Our ref: RA/2024/147049/03-L01
Your ref: 2024/90792
Date: 18 December 2024

(AMENDED PLANS SUBMITTED – REVISED FLOOD RISK ASSESSMENT) USE OF LAND FOR ASSEMBLY AND STORAGE AND FIT-OUT OF ACOUSTIC CONTAINERS OF CONTAINER-BASED GENERATOR UNITS WITH REINSTATEMENT OF ACCESS, ERECTION OF SECURITY FENCE AND SITING OF CABINS FORMER WHITELEY ENGINEERING WORKS SITE, ST. PEG LANE, CLECKHEATON, BD19 3SH

We have reviewed the revised Flood Risk Assessment (Ref 182623-F02, Rev B, dated 27/9/2024) submitted in support of this application and maintain our previous objection. Please see our updated response below. I would also draw to your attention that I have signposted to the applicant our planning advice service as, from a flood risk perspective, we consider issues related to this development proposal could be addressed.

Client		
Wakefield Acoustics Limited		
Project		
Land Off, St Peg Land, Clekheaton, BD19 3SA		
Title		
Modelled Flood Extents from the 2009 Study (JBA Consulting)		
Report No.	Drawing No.	Revision
182623-F01	06	-
Scale	Date	Frame Size
As Shown	29/1/2024	A3
Produced By	Drawn By	Approved By
RW	RW	HF

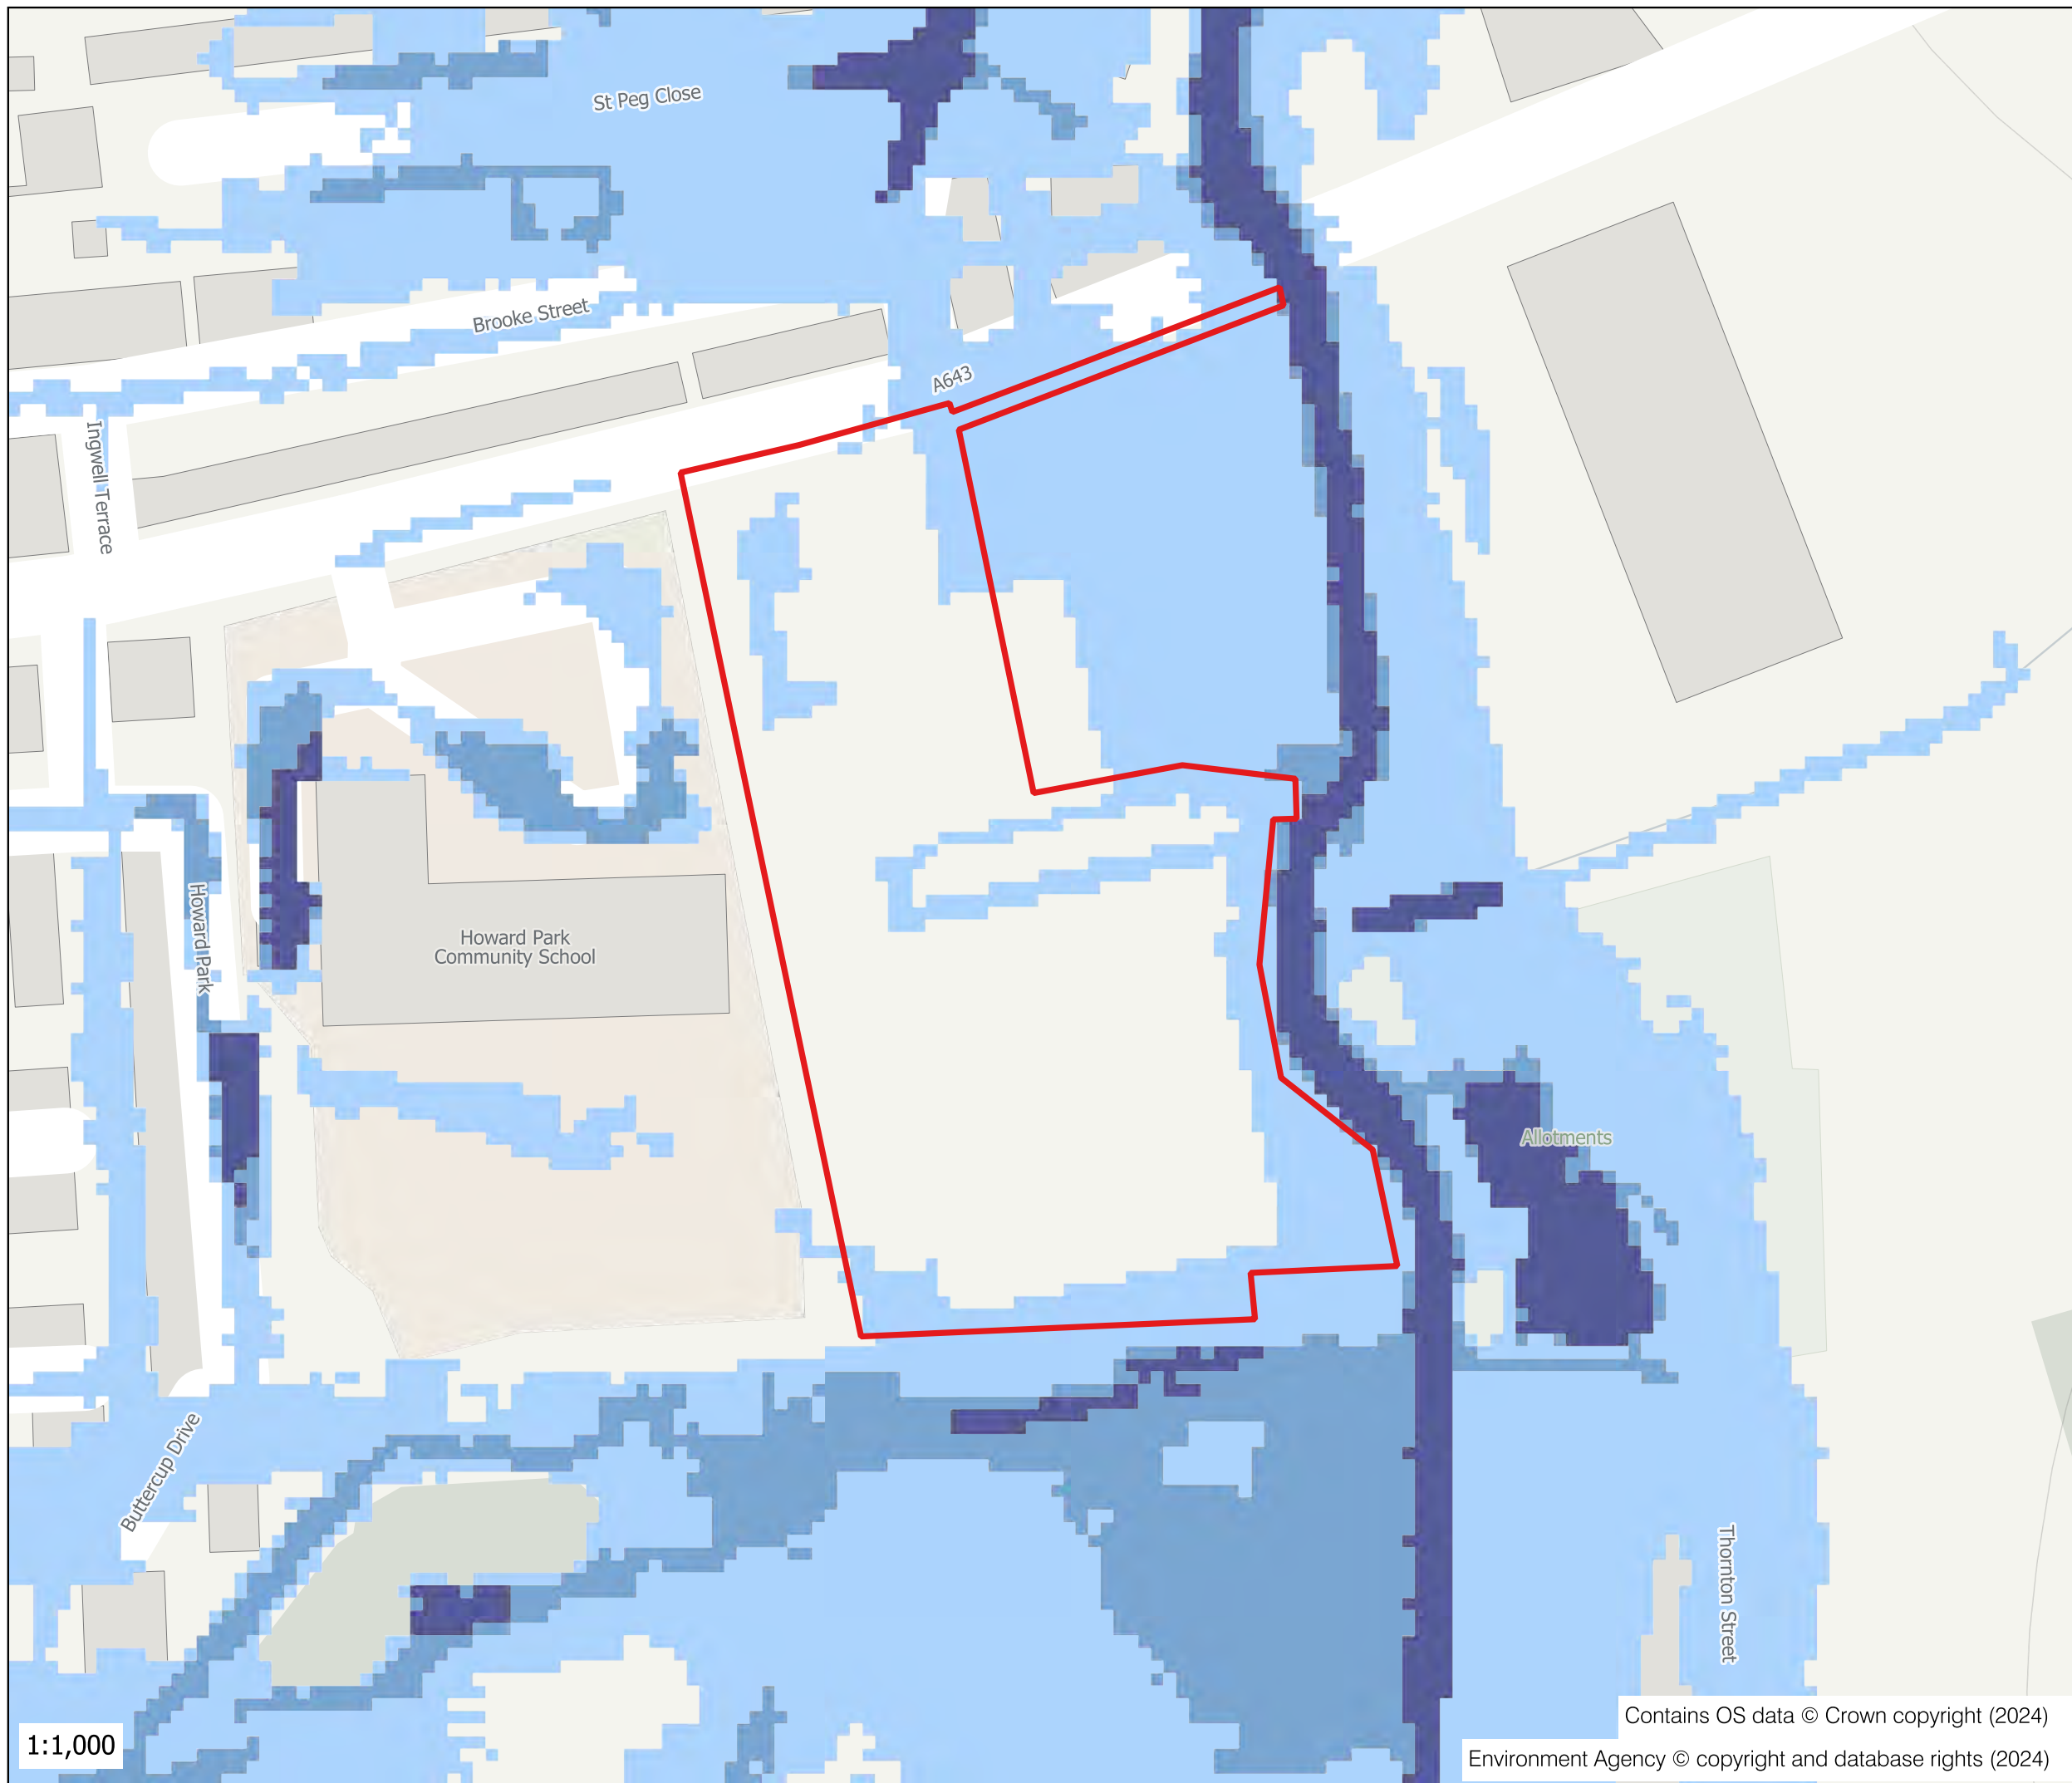
- Does not provide sufficient evidence to the extent of on-site flooding
- Does not satisfactorily demonstrate that the development wouldn't flood during the design flood event
- Isn't conclusive to show that the site wouldn't flood using the "Modelled Flood Outlines from the 2009 Study (JBA Consulting)" drawing provided in the updated FRA as this drawing is covered up by other layers. This is also not sufficiently detailed or site specific
- Fails to satisfy previous objections

To overcome our objection, the applicant should submit a revised FRA which addresses the points highlighted above.

The revised FRA should present what the design flood level is and should compare this to the site-specific topographical survey; this should clearly demonstrate what would be the design flood extent.

The applicant will also need to do a site-specific assessment and show where the development will be in relation to the design flood extent to ensure any increases in risk are adequately mitigated.
